**KIRKLEES METROPOLITAN COUNCIL
INVESTMENT & REGENERATION SERVICE**

**DELEGATED DECISION FOR DISCHARGE OF CONDITION A.4 -
NOTIFICATION OF A PROPOSED ENLARGEMENT TO DWELLINGHOUSE**

Reference no.	2018/HH/92308/W
Site Address	60, Holly Road, Thornton Lodge, Huddersfield, HD1 3SE
Description	The proposal is for erection of single storey rear extension. The extension projects 3.6m beyond the rear wall of the original dwellinghouse. The maximum height of the extension is 4m, the height of the eaves of the extension is 2.65m
Recommending Officer	Hannah Thickett

BLOCK/SITE PLAN
 AREA 36m x 36m
 SCALE 1:200 on A4
 CENTRE COORDINATES: 413398, 415666

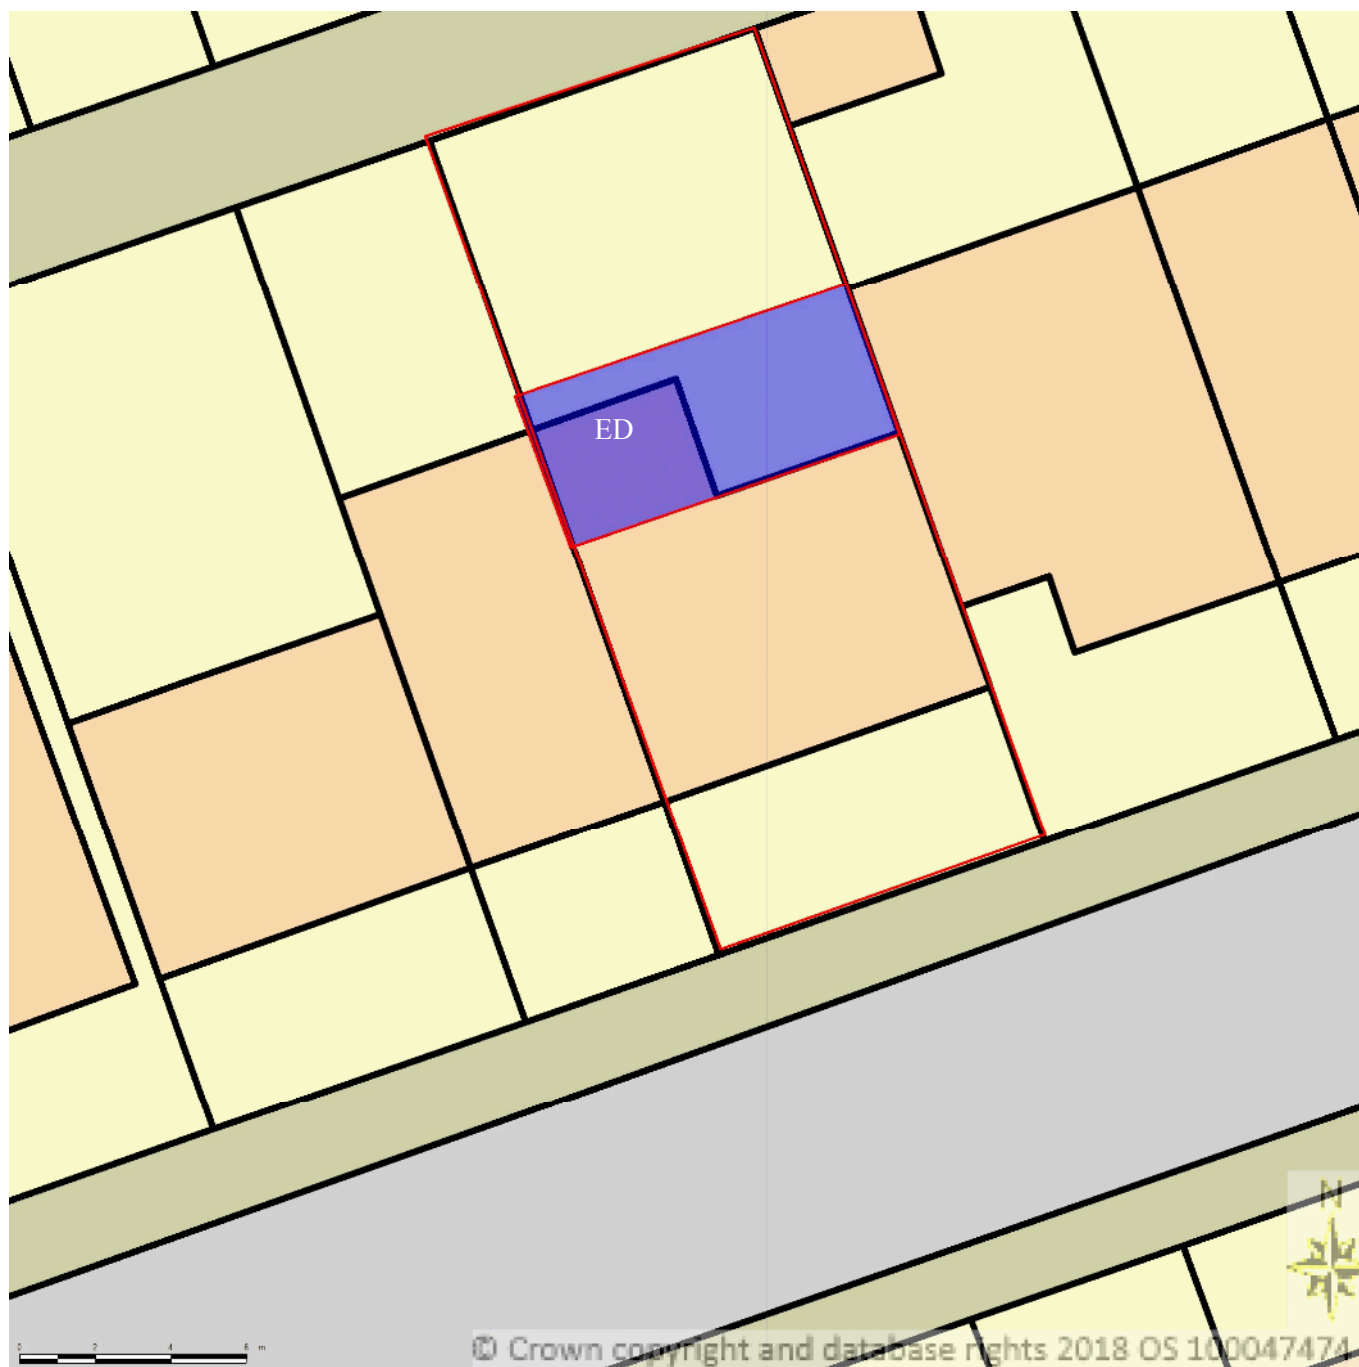
This proposal does not qualify for the criteria of permitted development. The development extends beyond the wall forming an original side elevation of the original dwellinghouse and is greater than half the width of the original dwelling. This would exceed the limitations set out in sub section (j)(iii) and ja.
